15 February 2023

6/2022/2901/HOUSE – 42 Daffodil Close

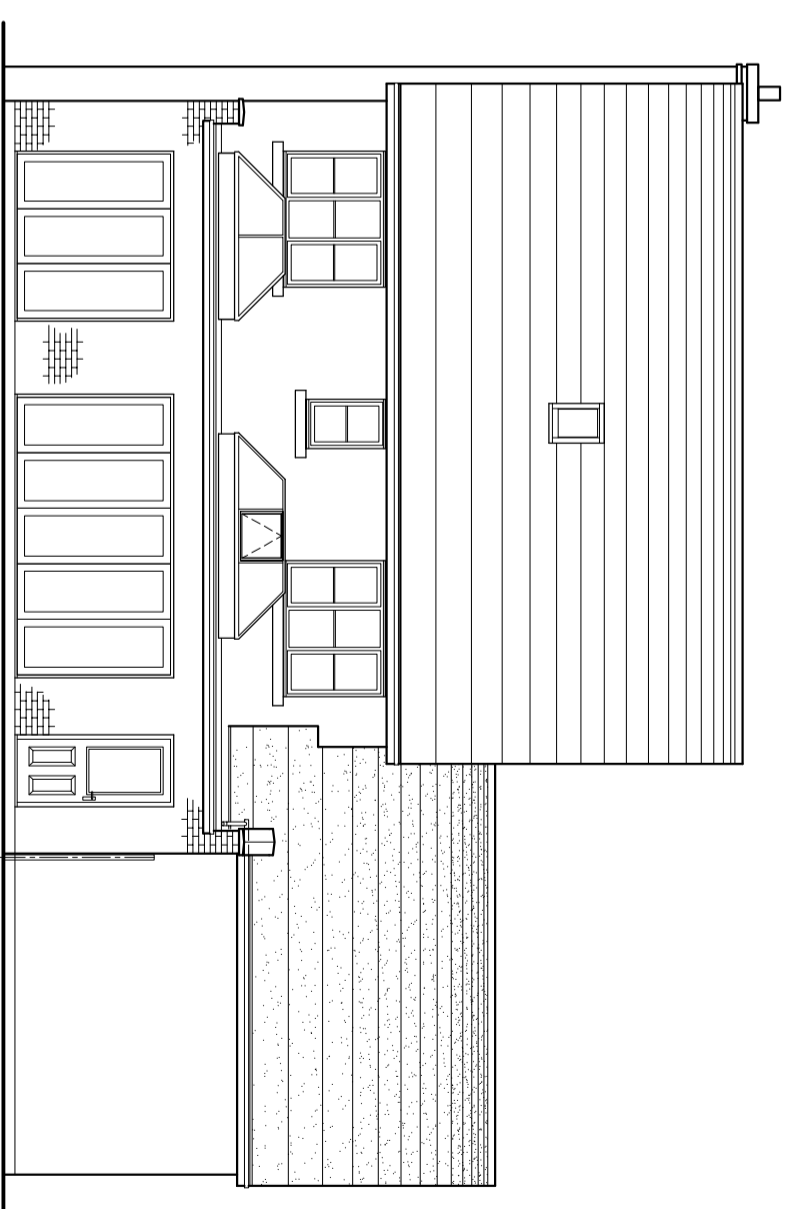
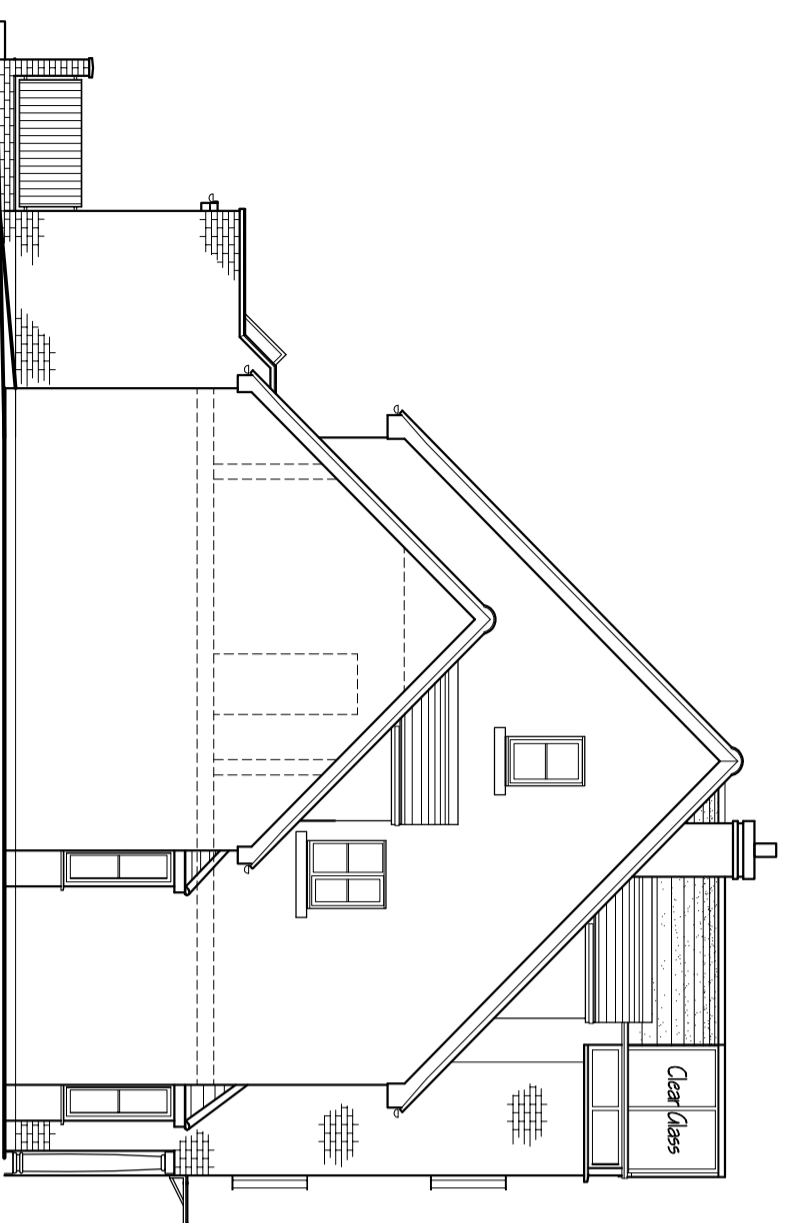
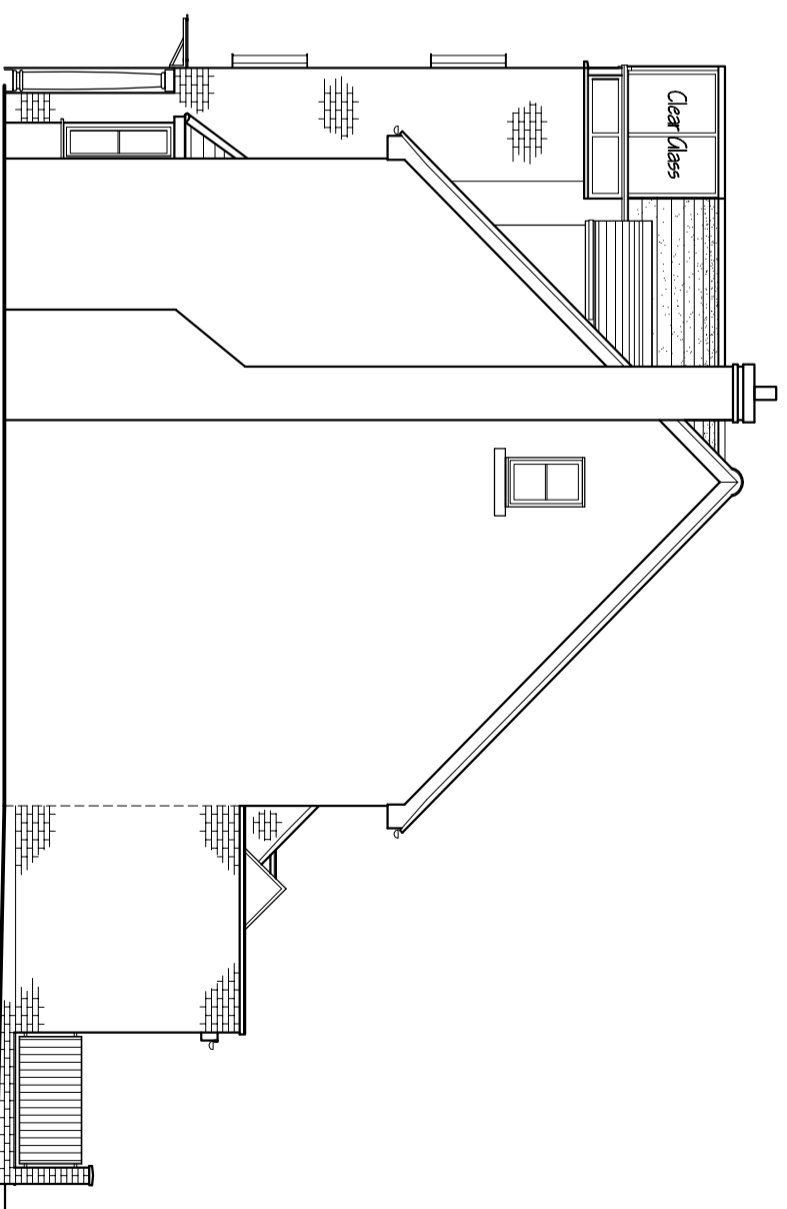
Having considered the application, the Town Council would like to raise a **Major Objection** should planning officers be minded to grant planning permission. We have assessed the proposed plan to be grossly out of keeping with the rest of the street, in particular the 3 storey front extension which would dominate the street scene, and would extend the front of the house beyond the building line. Furthermore we have concerns about the garage conversion and extension which is likely to be overbearing to the neighbouring property at 40 Daffodil Close, and which will have dormer windows overlooking the garden of 40 Daffodil Close. Our Members were also concerned about the loss of two parking spaces due to the loss of the garage, and would like this to be taken into account by planning officers.

Title PROPOSED FLOOR PLANS - SHEET 3

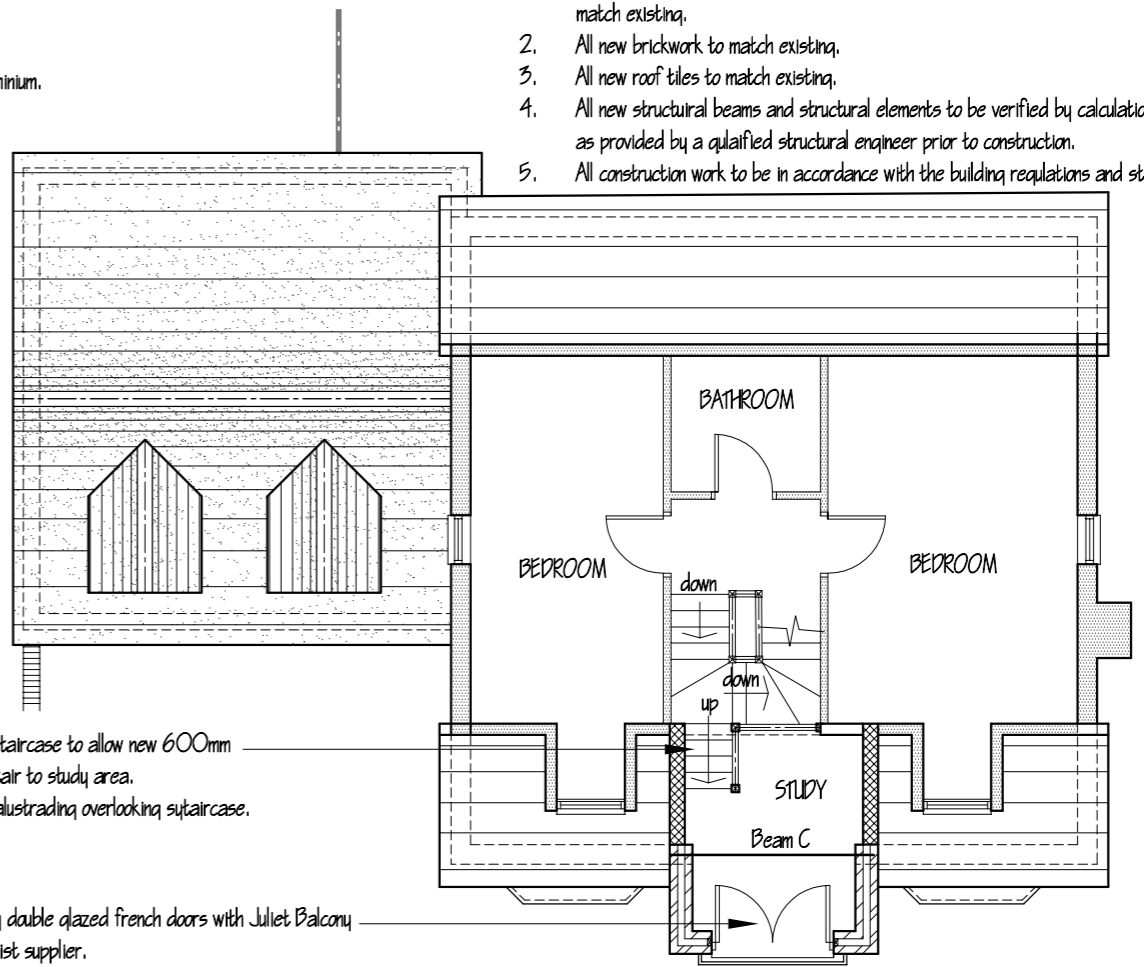
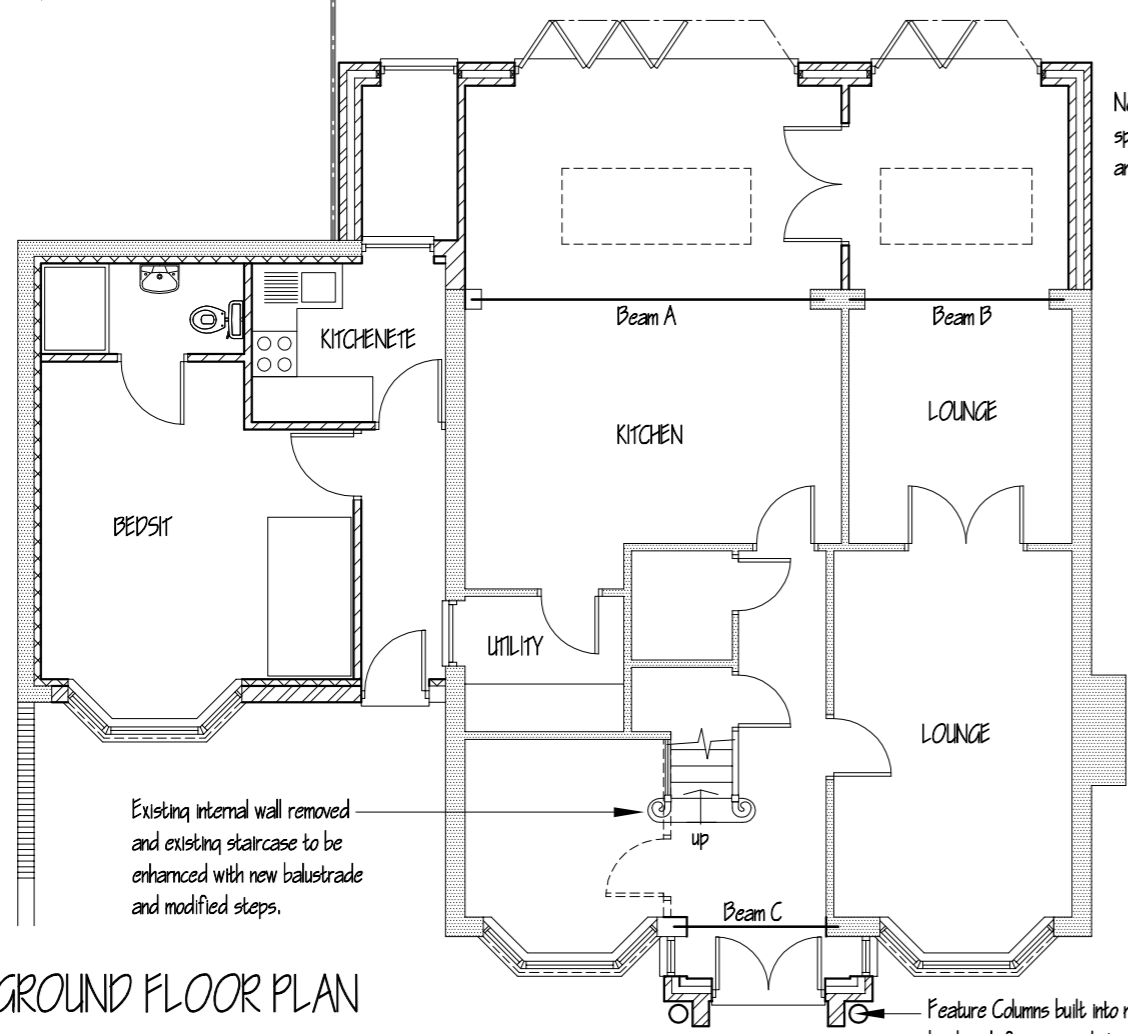
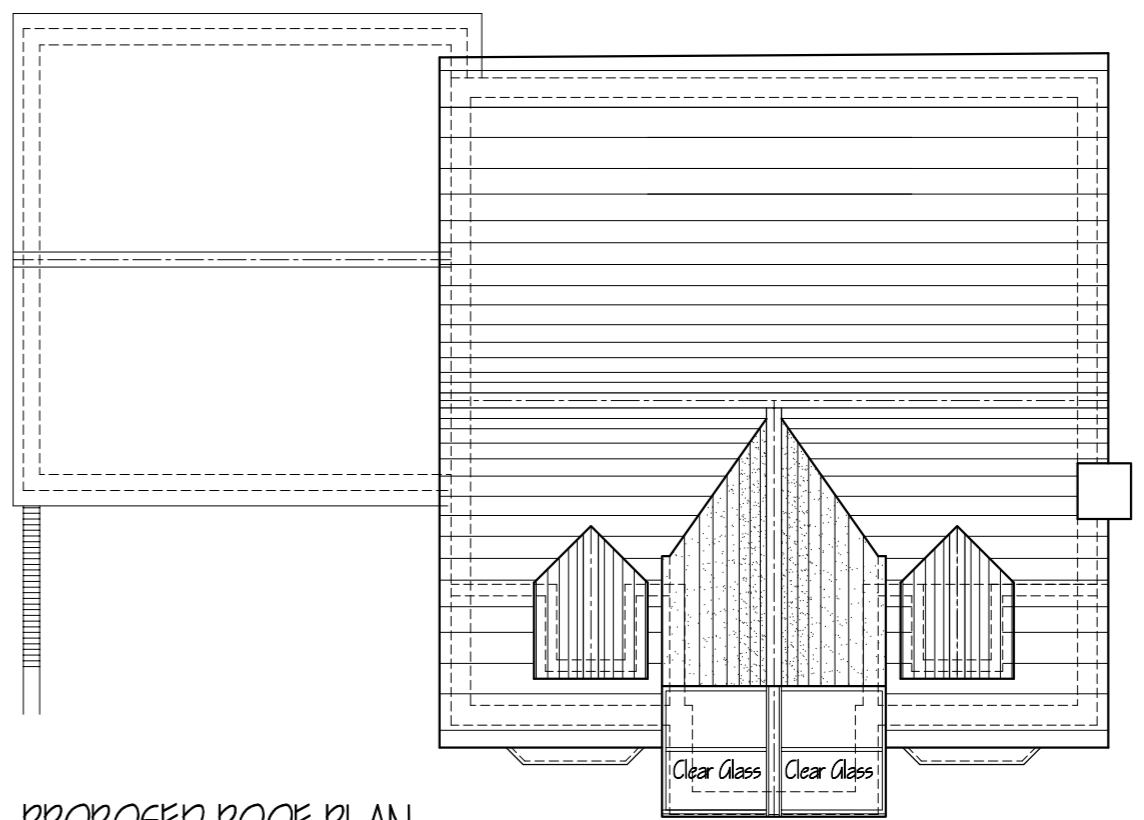
Should planning officers and the Development Management Committee be minded to grant planning application, we would suggest conditions are placed on the property which would prevent the “granny annex” being used as a separate dwelling, such as:

The outbuilding hereby permitted shall not be occupied at any time other than for purposes ancillary to the residential use of the dwelling known as 42 Daffodil Close.
